Date: 21-Oct-2025
Our Ref: 2025/92784

**Application for a non-material amendment following a grant of planning permission,
Town and Country Planning Act 1990**

Penistone Road/, Rowley Lane, Fenay Bridge, Huddersfield, HD8 0JS

Application Number: 2025/92784

2b3p End

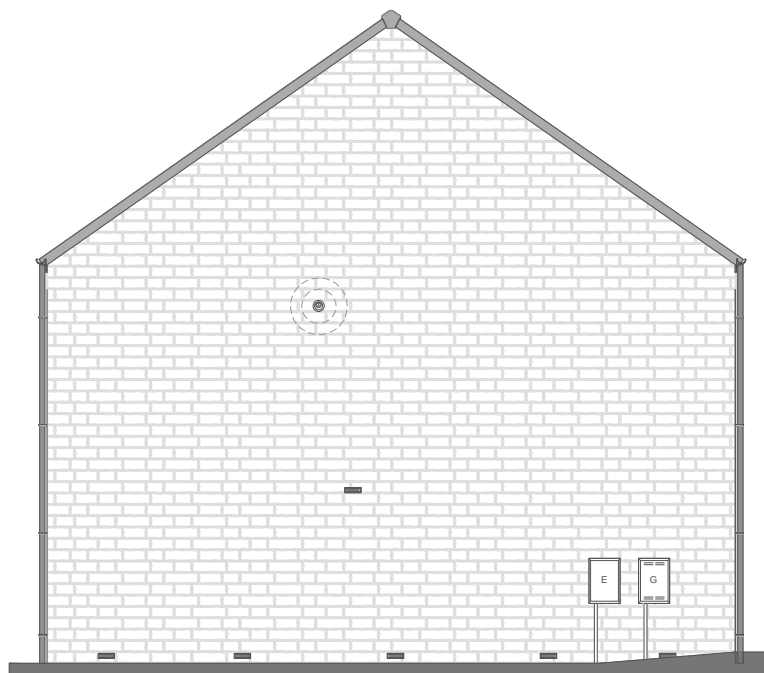
- Updated house types (Avocado and 2B3P), which include a larger window on the ground floor front elevation.

I confirm that the alterations are acceptable and may be considered as a non-material amendment to the approved drawings. It should be noted that this letter relates only to the non-material amendment sought and it is not a re-issue of the original planning permission. The two documents should be read together and as such, all conditions imposed on the original granting of planning permission apply to the proposal as now amended. A copy of this letter and the amended plans will be retained on the public record of approved documents.
